From: Iain Osenton
Sent: 25 September 2019 17:06
To: Caroline Ford; Tim Screen
Subject: RE: 15/00138/DISC - Bicester Eco Town Exemplar Site Banbury Road Bicester

From: Tim Screen <Tim.Screen@Cherwell-DC.gov.uk>
Sent: 02 September 2019 16:23
To: Caroline Ford <Caroline.Ford@Cherwell-DC.gov.uk>
Subject: 15/00138/DISC - Bicester Eco Town Exemplar Site Banbury Road Bicester

North Frontage Soft Landscape Plan Final Scheme PL402 P04

South Frontage Soft Landscape Plan Final Scheme PL401 P05

PROJECT NO. ALD654	DRAWING NUMBER: PL401	REVISION: P05
-----------------------	--------------------------	------------------

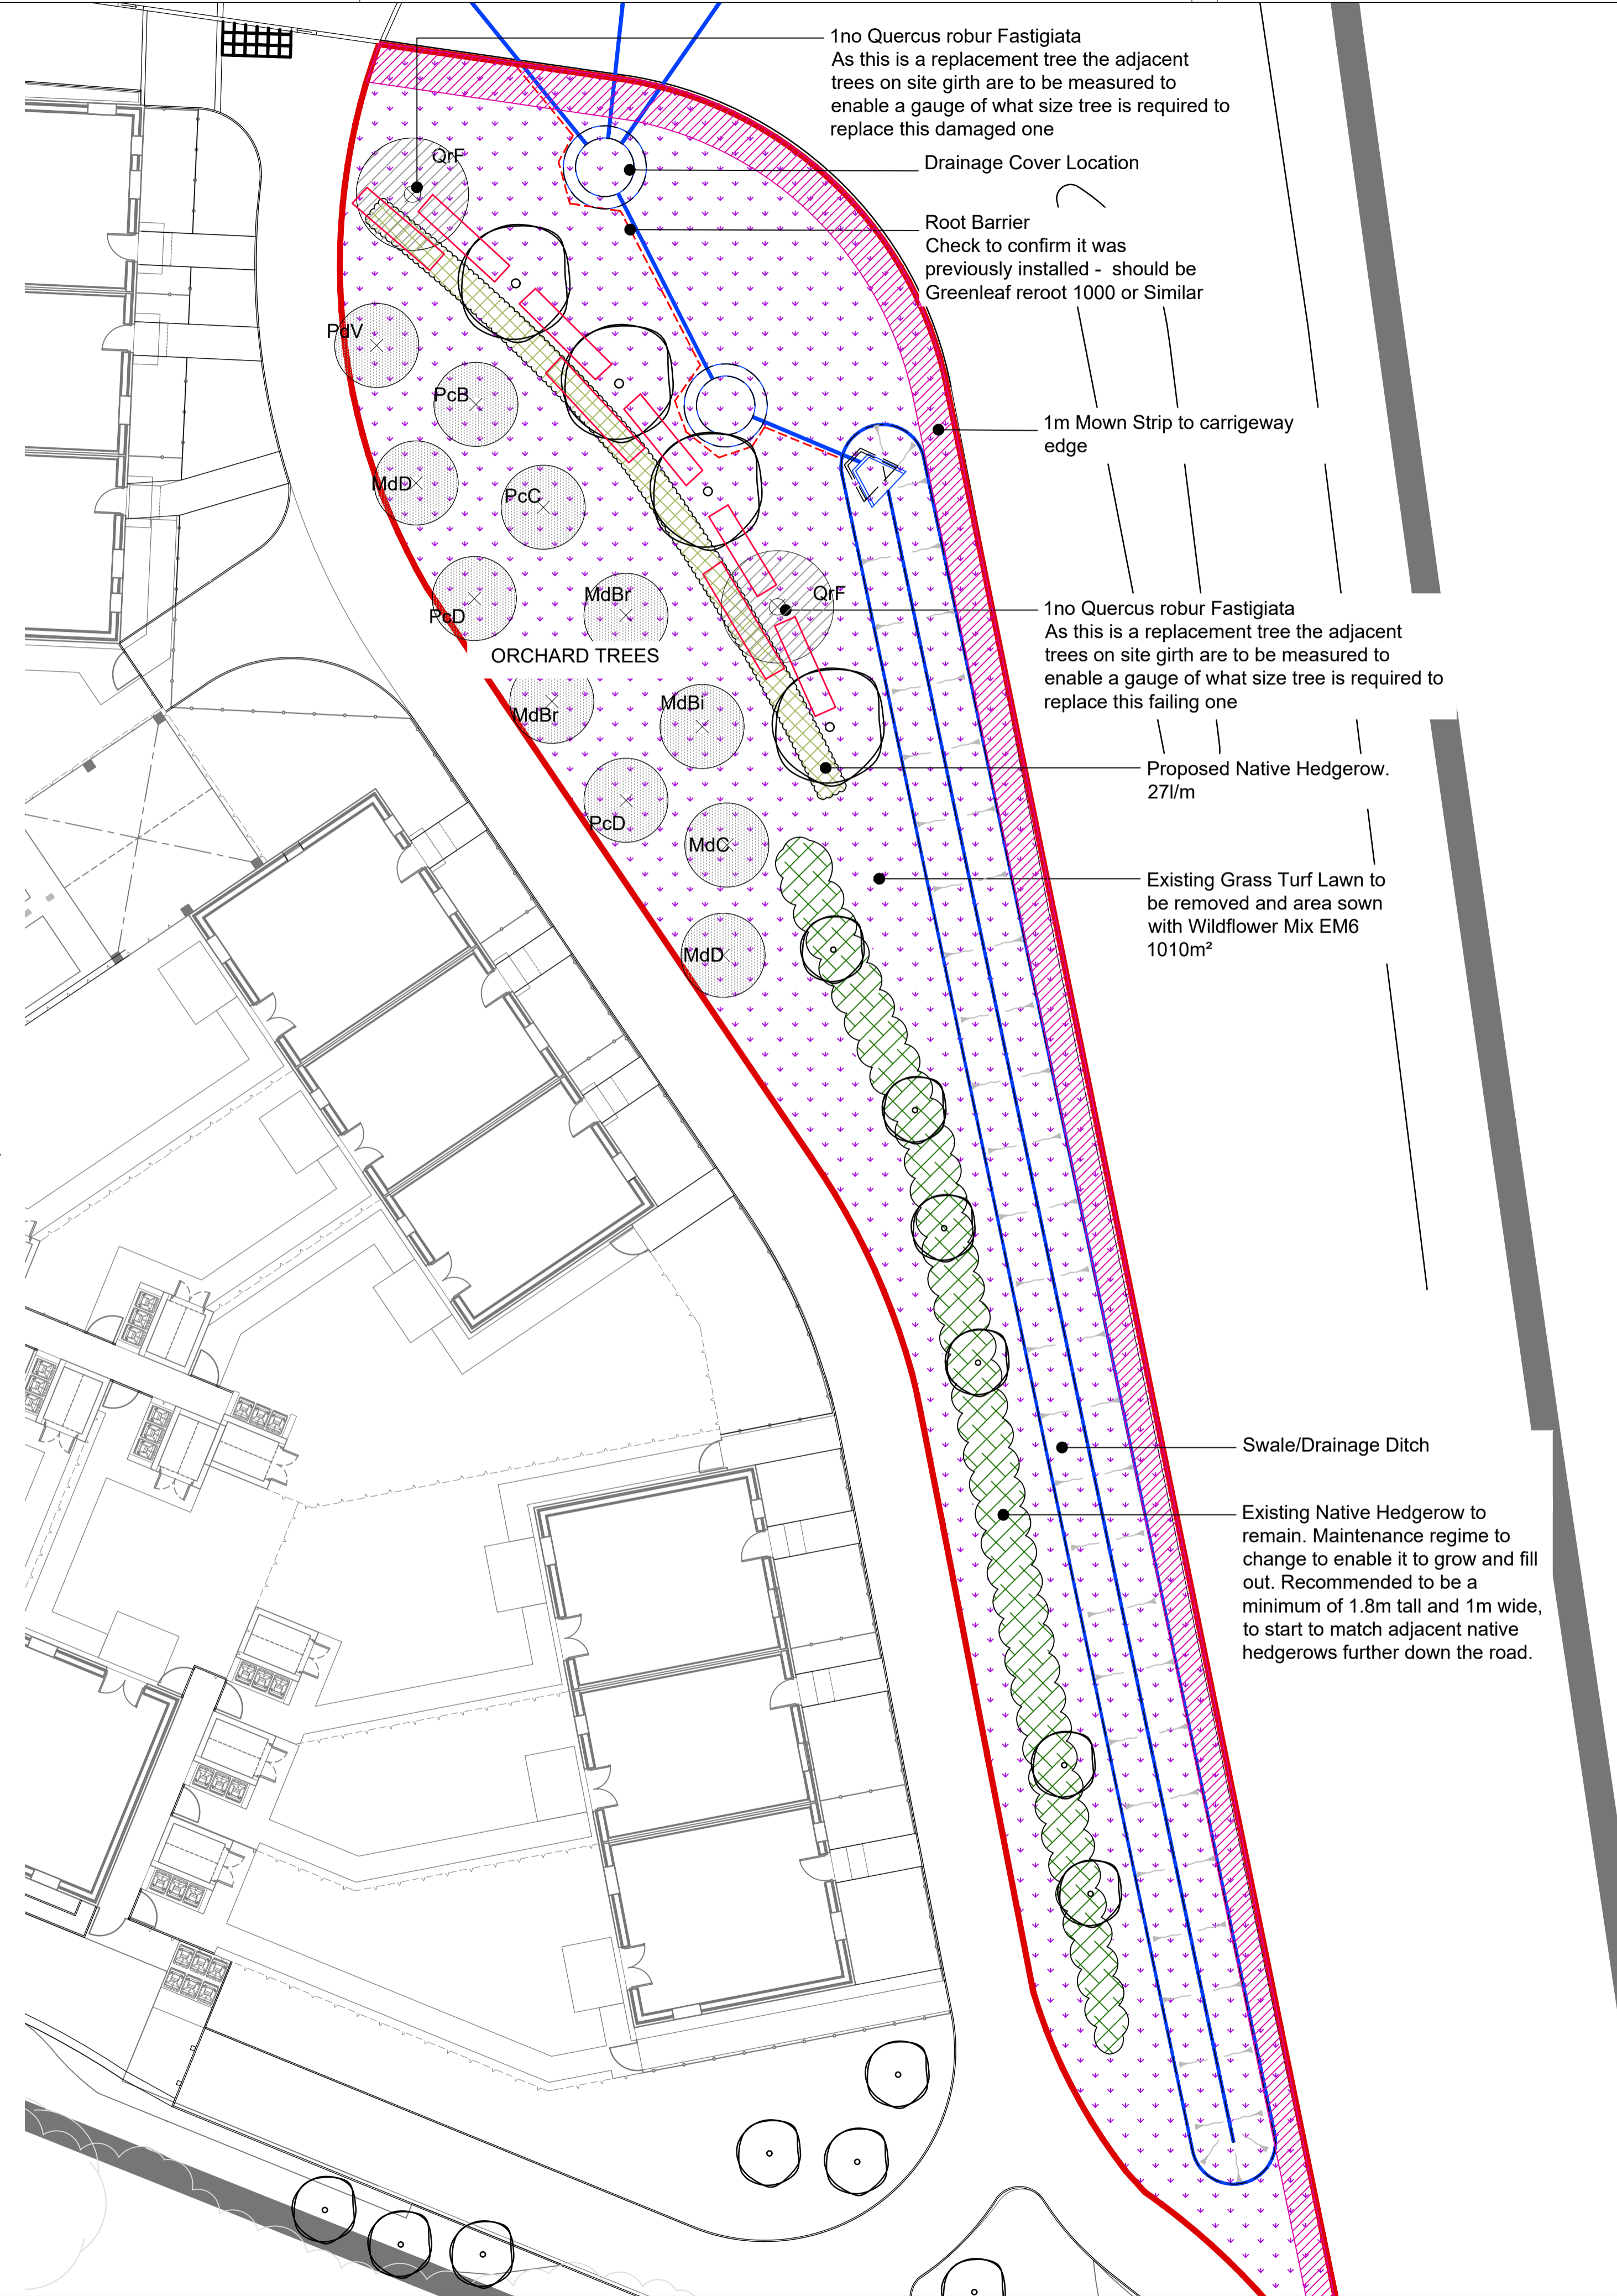
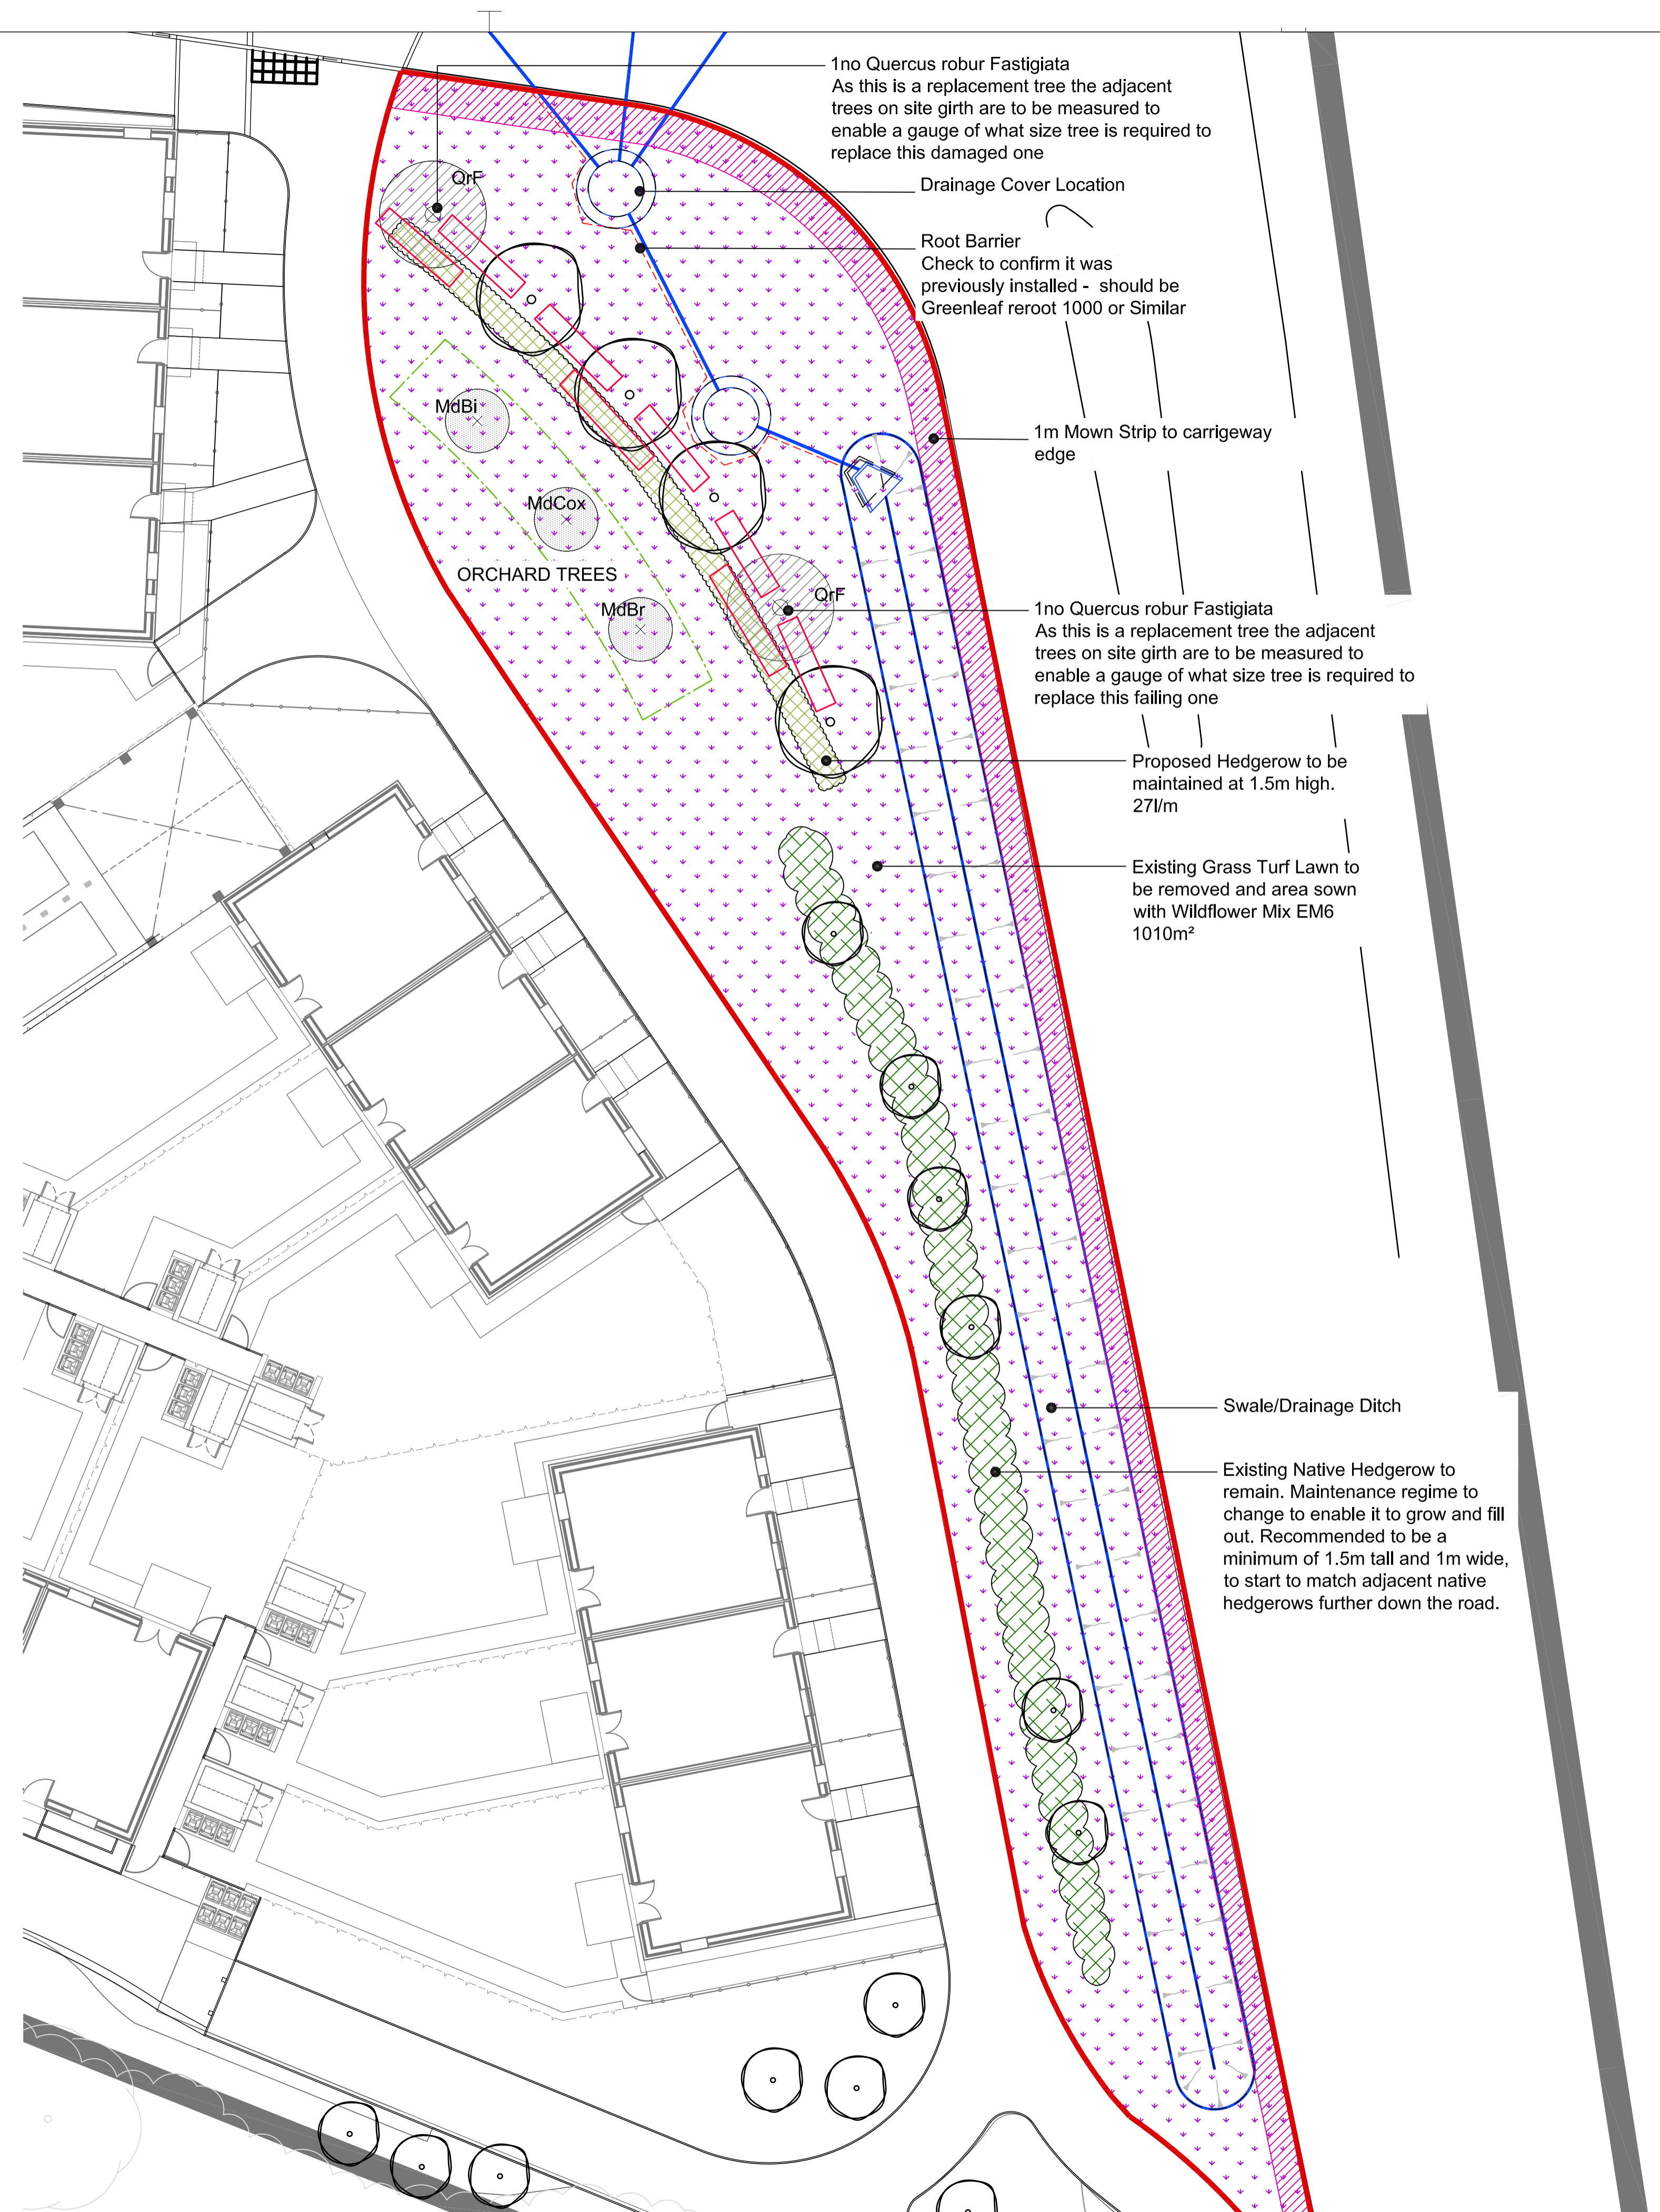
I think a formal hedge will be more appropriate with the arc of fastigiata oaks. A single species formally clipped *Carpinus betulus* (hornbeam) hedge is recommended. The hedge is to follow the arc of the trees, but avoid cultivating and damaging the establishing tree roots. Plant in a double-staggered row, 45 cm plant spacing.
